Ribble Valley Borough Council  
Council Offices  
Church Walk,  
Clitheroe  
Lancashire  
BB7 2RA

Phone: 0300 123 6780  
Email: [developeras@lancashire.gov.uk](mailto:developeras@lancashire.gov.uk)  
Your ref: 3/2025/0218  
Our ref: 3/2025/0218/HDC/KW  
Date: 03 June 2025

**Location:** Cherry Yate Stoneygate Lane Ribchester PR3 3YN  
**Proposal:** Proposed 1.25m high garden wall and new gate piers set back 5.5m from highway.  
**Grid Ref:** 365182 436114

Existing and Proposed Site Layout Plans

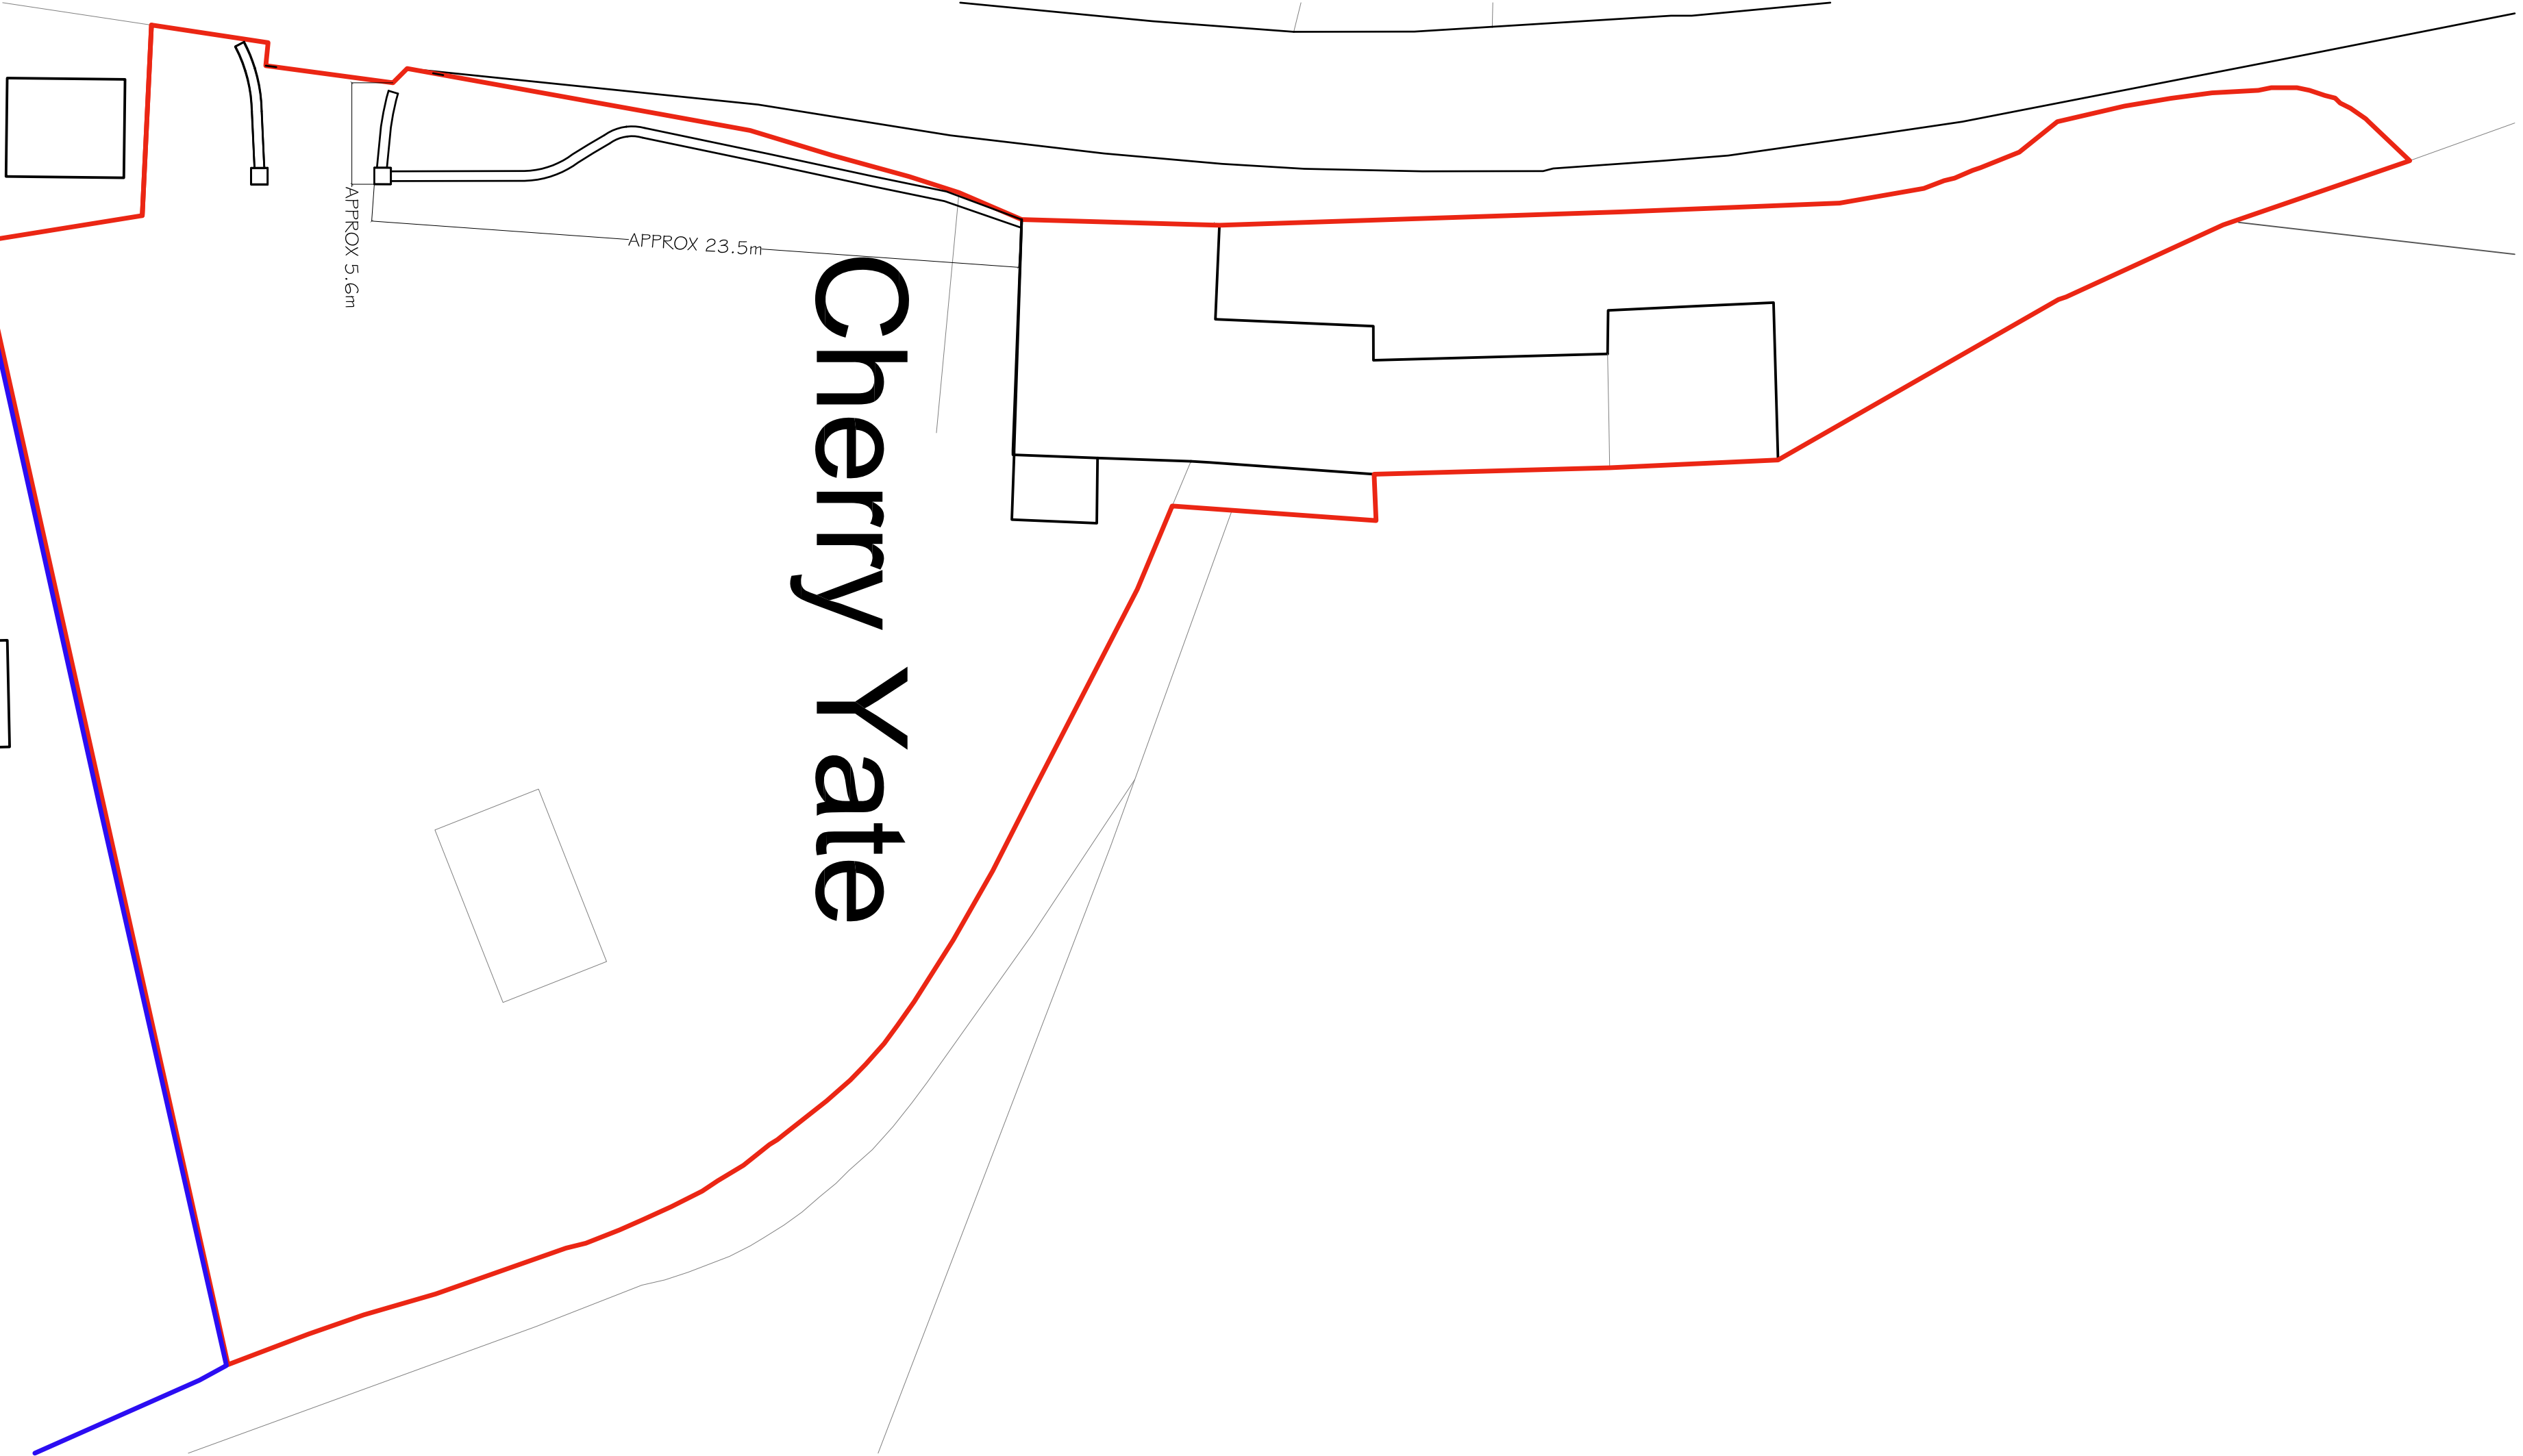
The LHA has reviewed the amended proposed site plan and notes that amendments are being undertaken to the boundary wall adjacent to the adopted highway. The proposal seeks to improve the existing access by setting back the gates and reducing obstructions in the existing visibility splay.

Whilst the proposal does not meet the current requirements for an access, it will be a betterment to the existing arrangements, in that a vehicle will now be able to fully pull off the carriageway before operating the gates, removing conflict from the carriageway. The access will also have improved surfacing, which will remove the risk of debris being deposited onto the highway. The application will also remove obstructions within the visibility splay by removing the boundary hedge line and replacing it with a wall which will reduce the need for maintenance of the visibility splay. The proposal is also not intensifying use within the site and as such the LHA will accept the proposal in this case.

1. Before the access is used for vehicular purposes, any gateposts erected at the access shall be positioned a minimum of 5m behind the nearside edge of the carriageway. The gates shall thereafter open away from the highway.

**Reason:** To permit vehicles to pull clear of the carriageway when entering the site and to assist visibility.
2. Before the access is used for vehicle purposes, that part of the access extending from the highway boundary for a minimum distance of 5m into the site shall be appropriately paved in tarmacadam, concrete, block pavements, or other hard material to be approved by the Local Planning Authority.
